From: ENVU Biodiversity and Land Use
Sent: 24 March 2026 12:51
To: Kerri Simpson
Cc: Planning ContactCentre
Subject: 2025/93225 at location The Richardson Arms, 684, Bradford Road, Oakenshaw, BD12 7EN

Please see ecological commentary below:

## **Appendix 4: Bat Roost Potential Map**

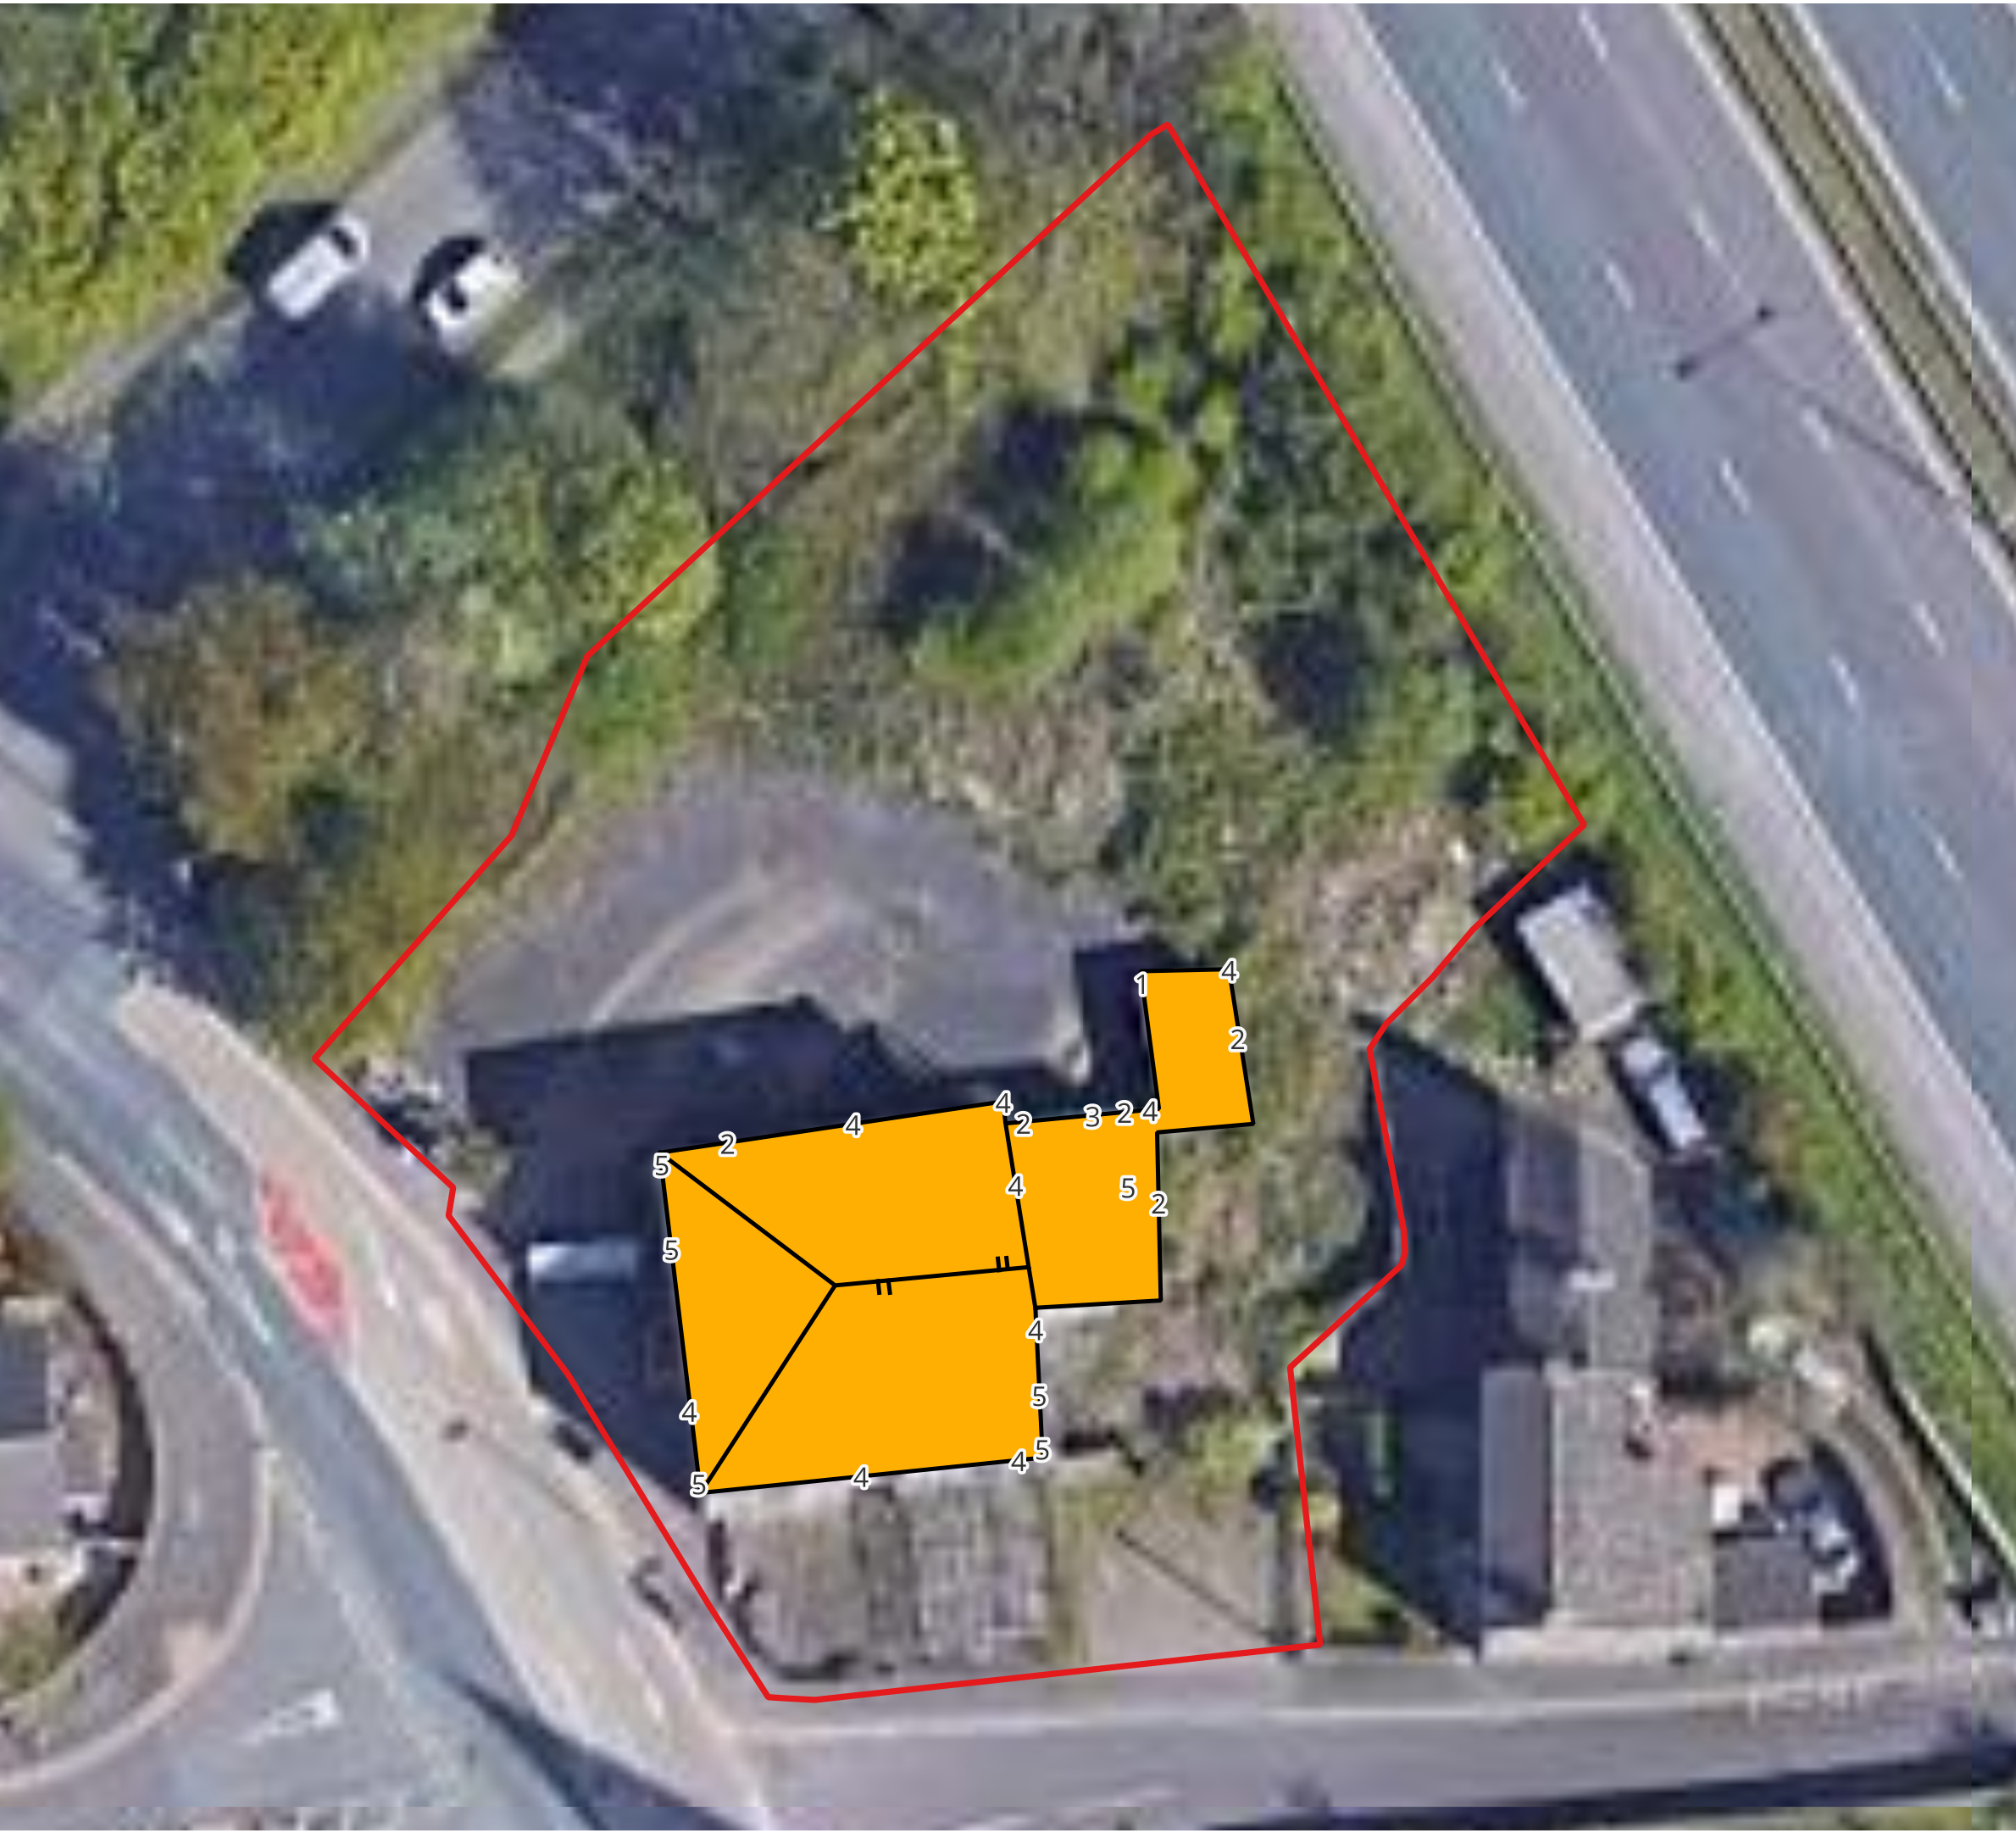
- Birds – the site has some suitability for nesting birds. Precautionary measures will be conditioned and added to a CEMP.
- Bats – the building onsite (B1 – a and b) was noted to have moderate suitability for roosting bats. The bat report provided confirmed that 1 no presence / absence survey was completed and it was observed that no bats were roosting in the building. However, the requirement was for 2 no surveys. An additional survey will need to be conducted prior to determination. The site has over low potential for foraging and commuting bats. Lighting strategy and tree protection measures for retained trees will be added.
- Hedgehog – the site offers some suitability for hedgehogs. Precautionary measures will be conditioned and added to a CEMP.
- Enhancements will also be added.

- 1 no additional bat survey must be completed prior to determination.
- BNG metric in excel format must be provided to complete commentary.
